**KIRKLEES METROPOLITAN COUNCIL  
INVESTMENT & REGENERATION SERVICE**

**DELEGATED DECISION TO DETERMINE PLANNING APPLICATIONS**

Reference No:	<b>2025/62/92786/E</b>
Site Address:	485, Bradford Road, Batley, WF17 8LB
Description:	Change of use of yard to car wash and erection of associated buildings
Recommending Officer:	Elenya Jackson

## **Officer Report – 2025/92786**

PROPOSED SITE PLAN
1:250 @ A1

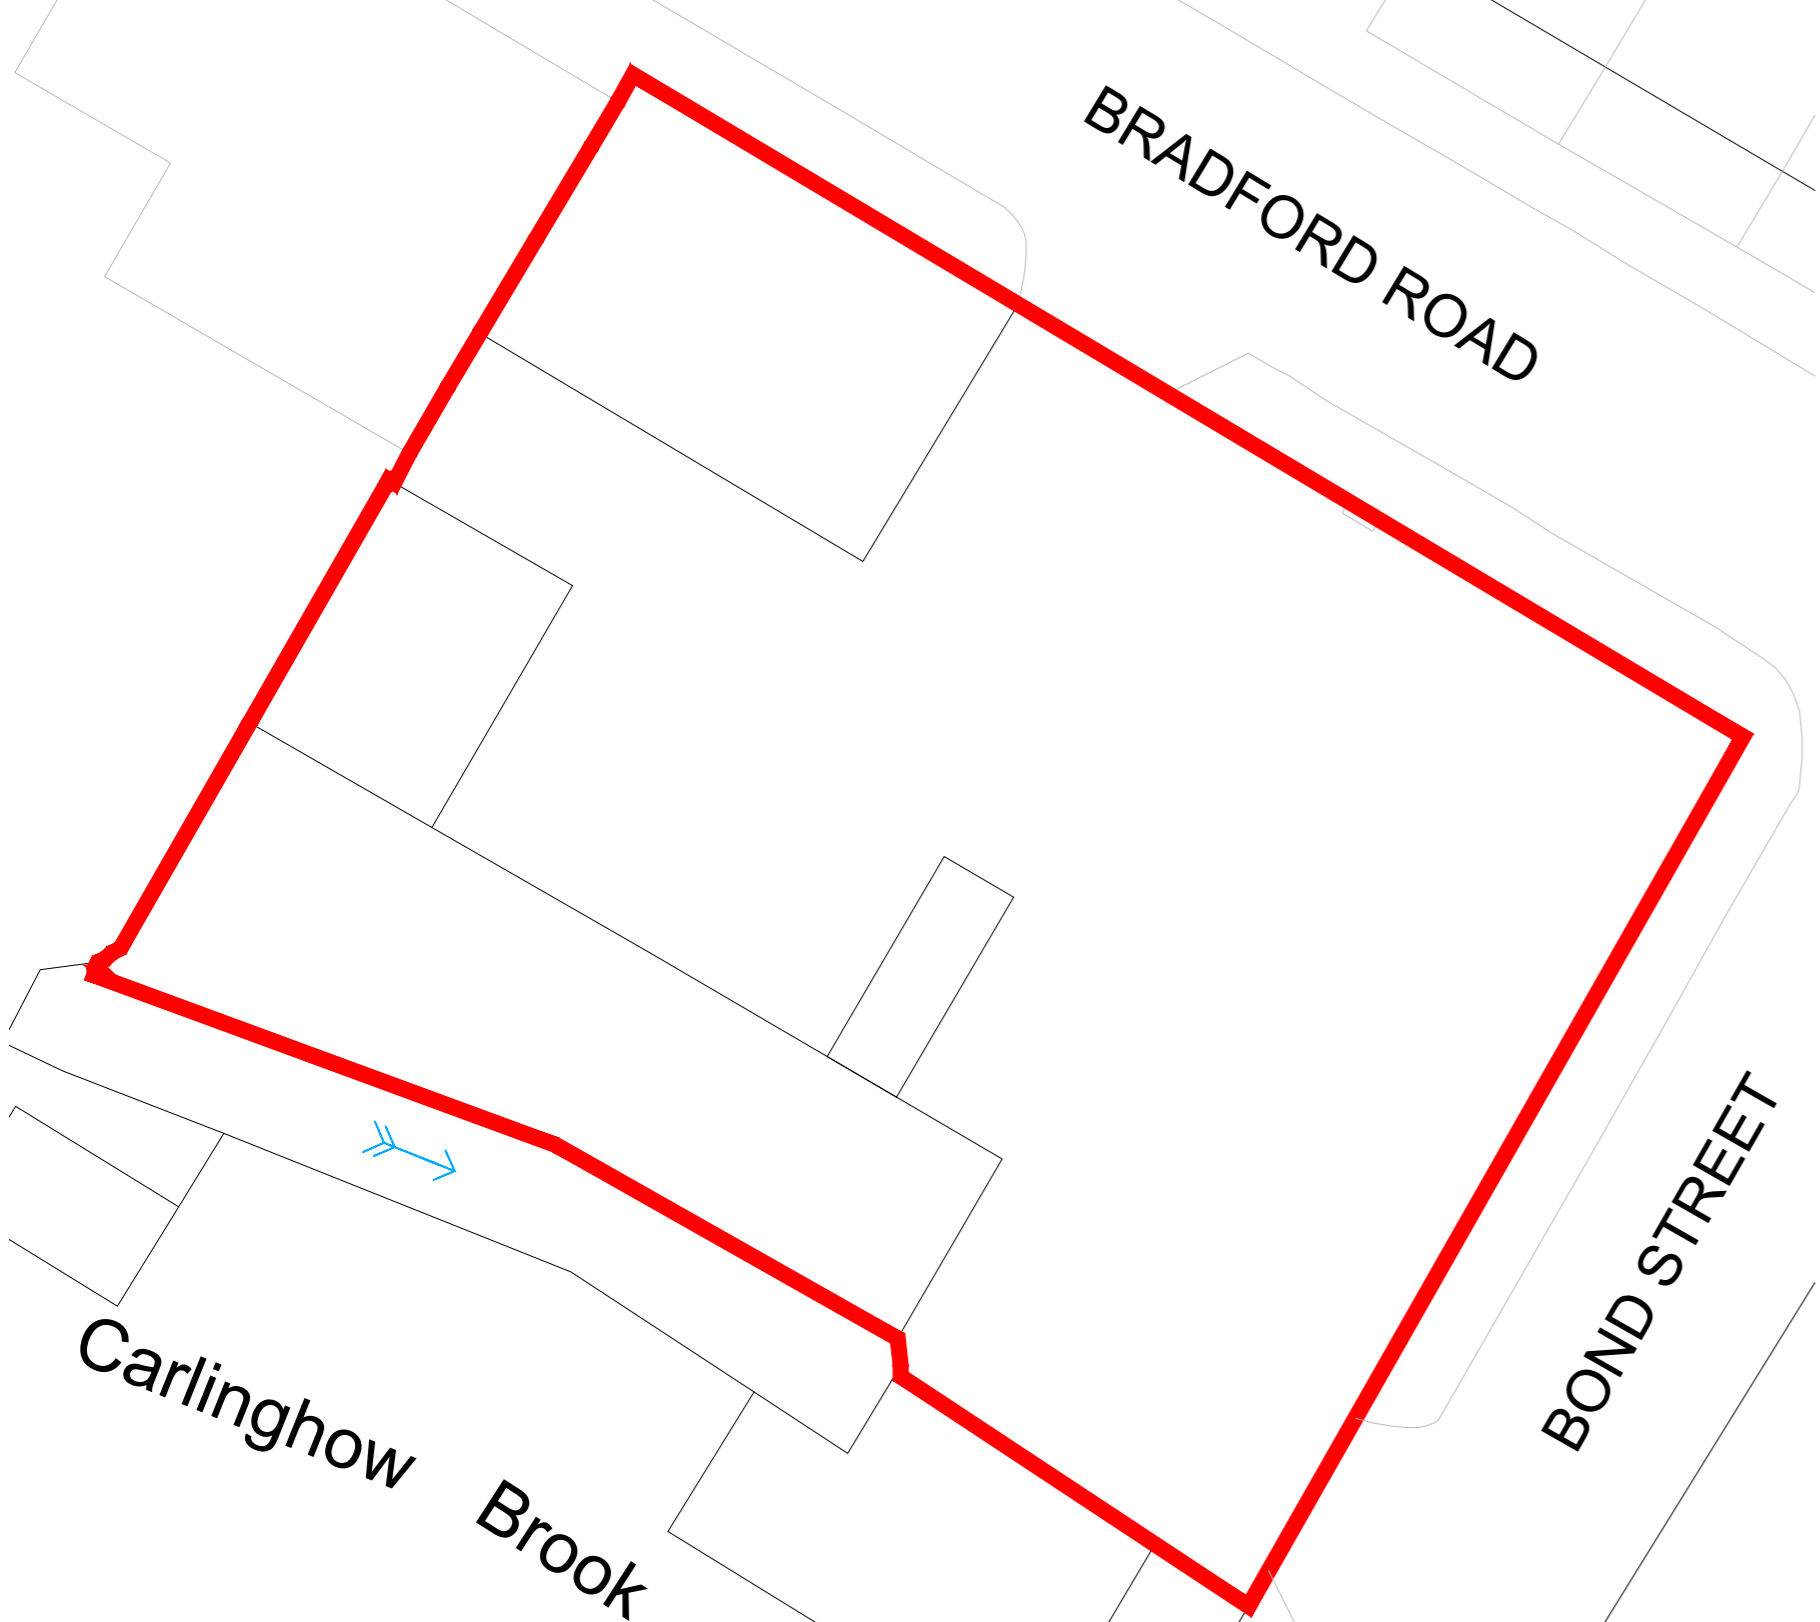
The proposal includes the utilisation of the existing access on Bradford Road and the re use of an existing access point on Bond Street. This would create separate entrance and exit points, enabling a one-way circulation system within the site.

Officers initially had concerns regarding the proposal introducing two blank elevations along Bradford Road, which was compounded by the proposed materials. In the event that planning permission be approved, it is recommended that a condition be attached for the use of red brick so as to be in-keeping with the site and characteristic of the area. The north-western elevation of the site has an existing building which is red brick and would result in the development, if conditioned to be finished in red brick, not being overly discordant. Therefore, subject to conditions, it is considered that it would not be inappropriate in this instance. It is considered reasonable and necessary, in the interests of visual amenity and in accordance with LP24 of the Kirklees Local, to secure by condition the submission and approval of details of the proposed materials and colour finish prior to installation to ensure the proposal would not give rise to unacceptable harm to the character or appearance of the area.

The proposed structures would be located 17m to the south of 528-534 Bradford Road. It is considered that this maintains adequate separation and the structures would not result in significant overshadowing or loss of light to these properties

The submitted information does not clearly demonstrate the full drainage arrangement or confirm how the gullies and interceptor connect prior to discharge.

PROPOSED FRONT ELEVATION
1:100 @ A1

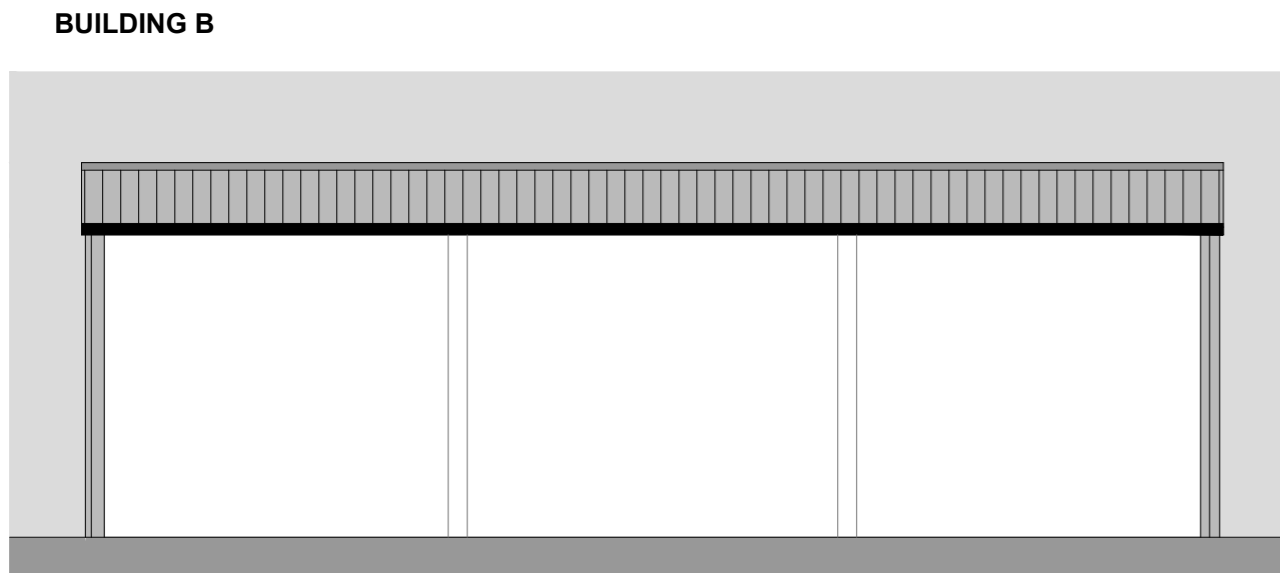
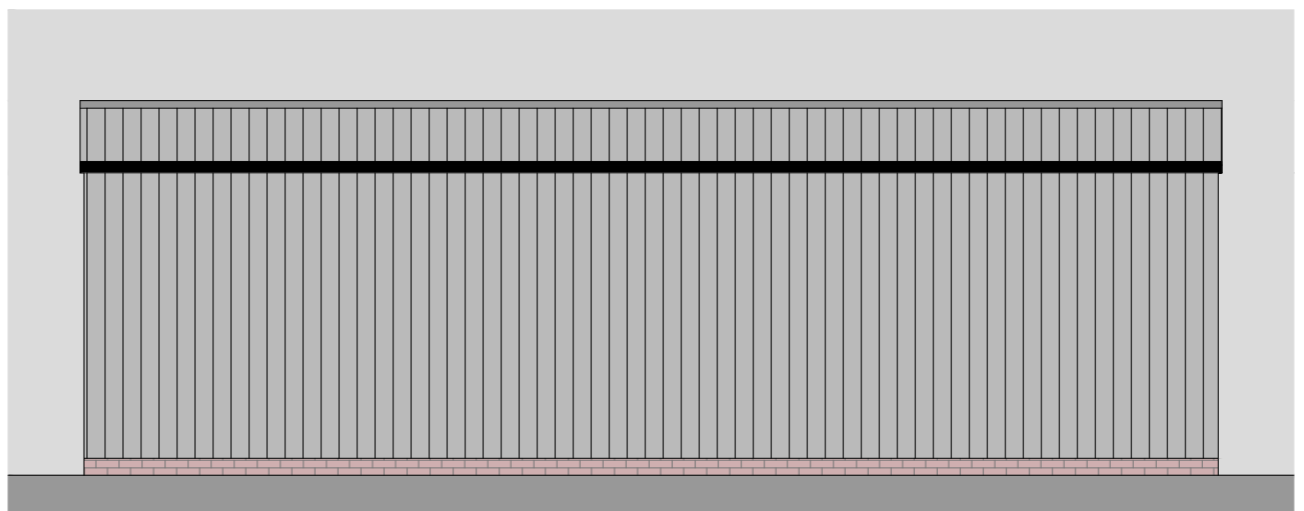
Building B would border onto Bradford Road to provide a valeting service for three vehicles and would have a width of 15m and have a maximum height of 5m.
